Our Ref: A/50/15/PL

**Town & Country Planning Act 1990 (as amended)
Town and Country Planning (Development Management Procedure) (England) Order 2015
Application for Planning Permission**

Development	Demolition of Spinney & Burberry House & erection of 2 Storey hotel annexe with associated car parking
Location	Premier Inn Spinney & Burberry House Roundstone Lane / Roundstone Road East Preston Angmering

| Drawing              |          |        |          |         |
|----------------------|----------|--------|----------|---------|
| 3789/P3              |          |        |          |         |

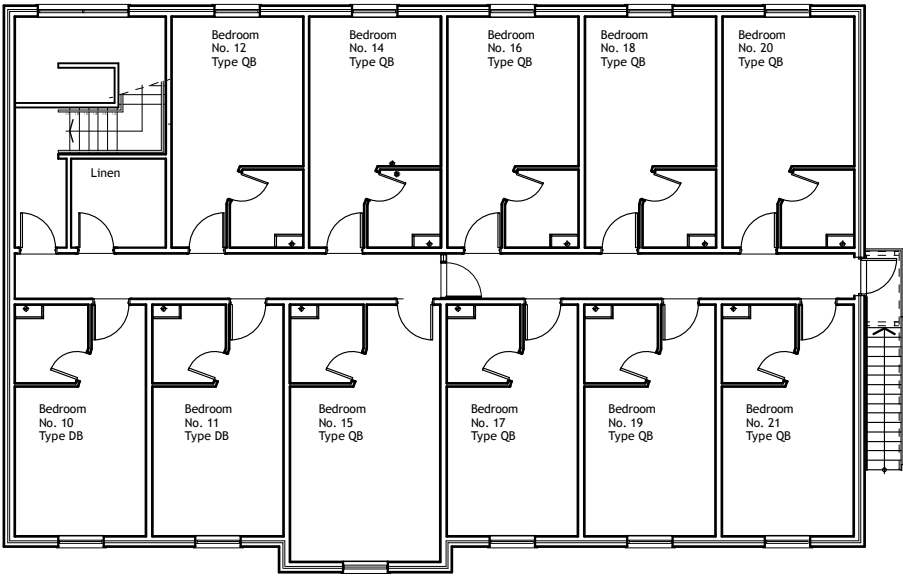
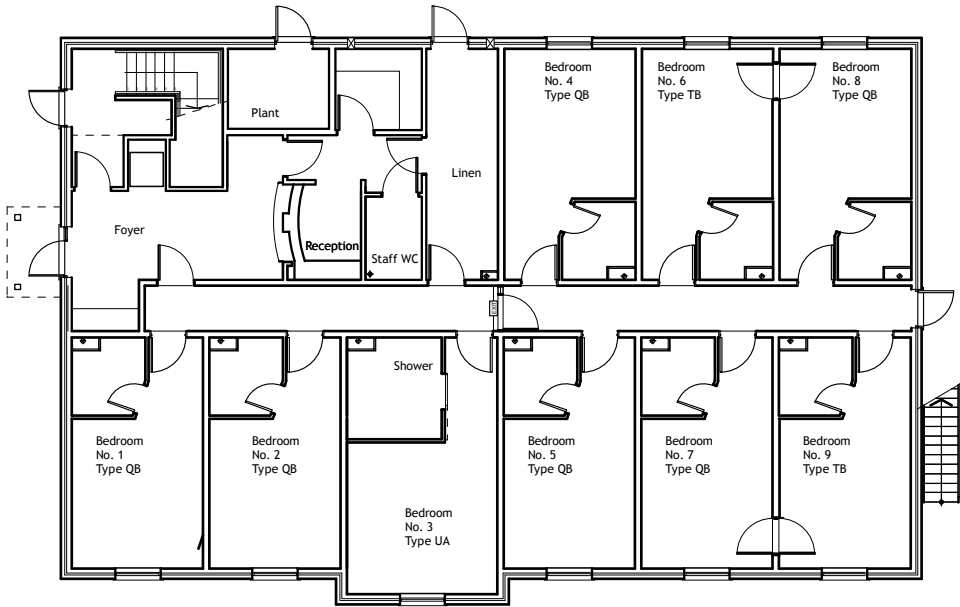
Please note the Existing plans (drawing no. 3789/P3) does not match the existing elevations.

PROPOSED SITE PLAN

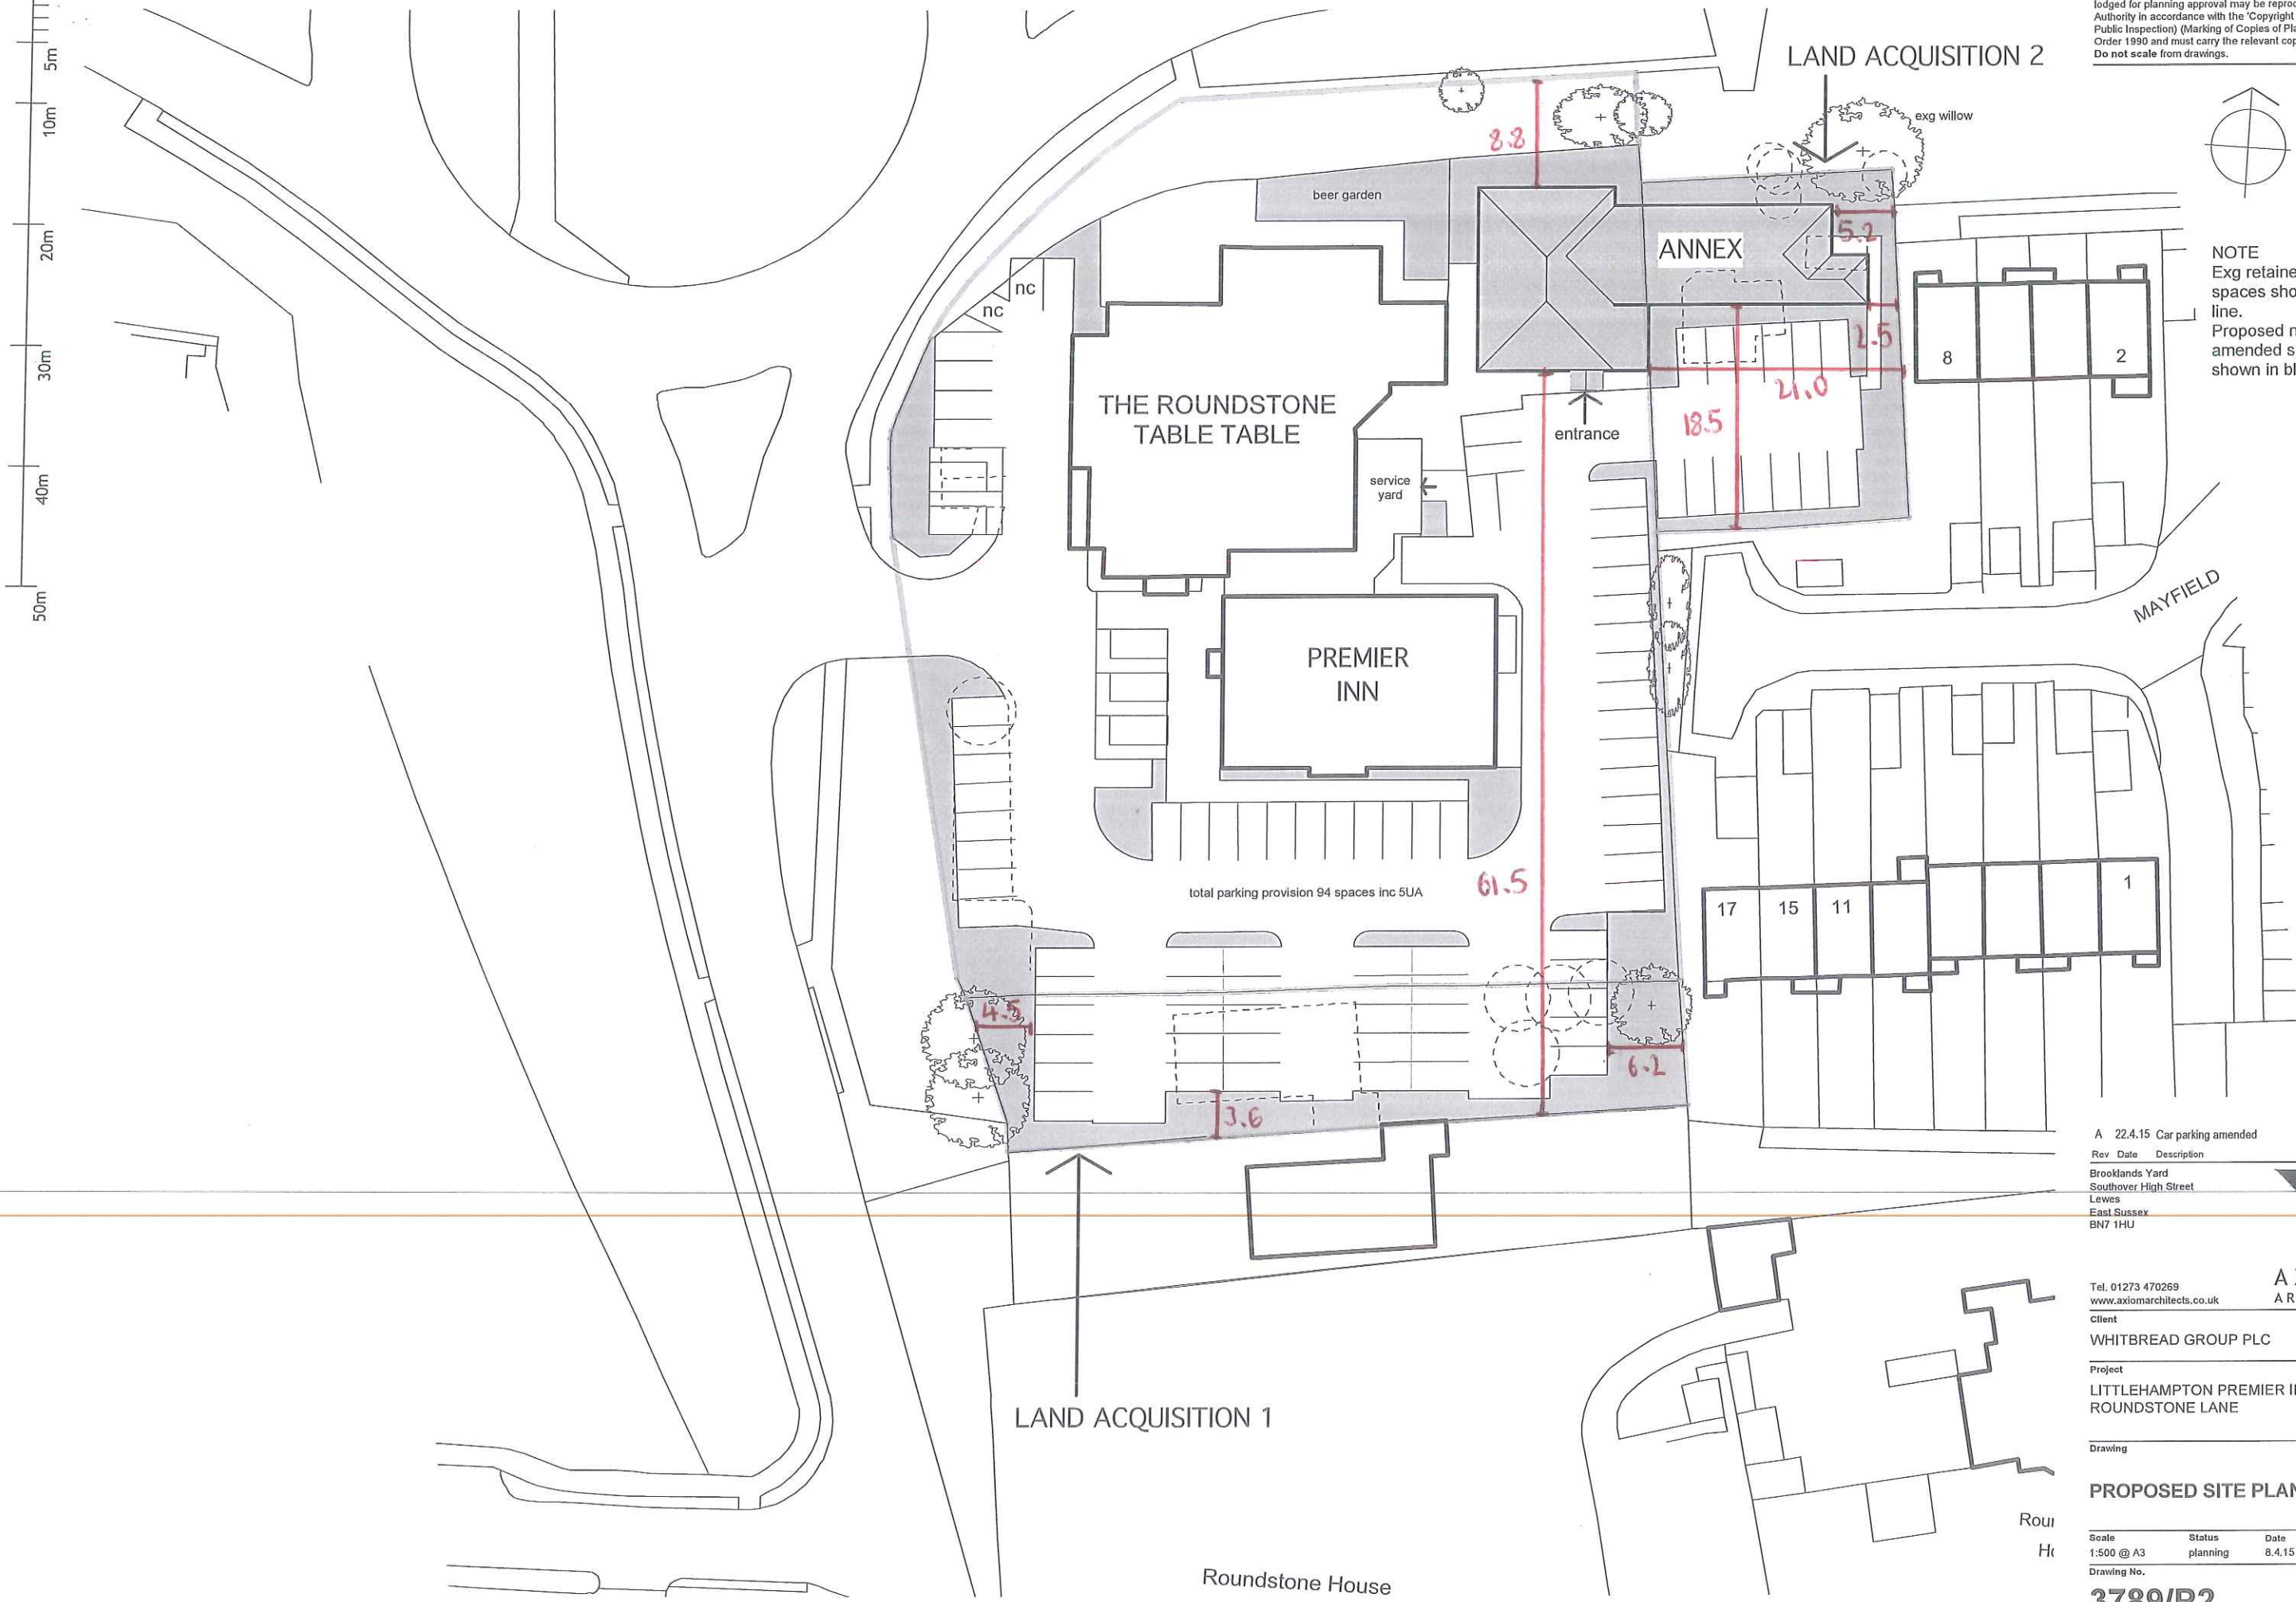
Please submit 1 electronic or 3 paper copies of a revised block/site plan at a scale of 1:500 or 1:200 with the site dimensions clearly indicated from the proposals to the site boundaries. Further details of what must be included on the plan can be found in the National Validation Requirements.
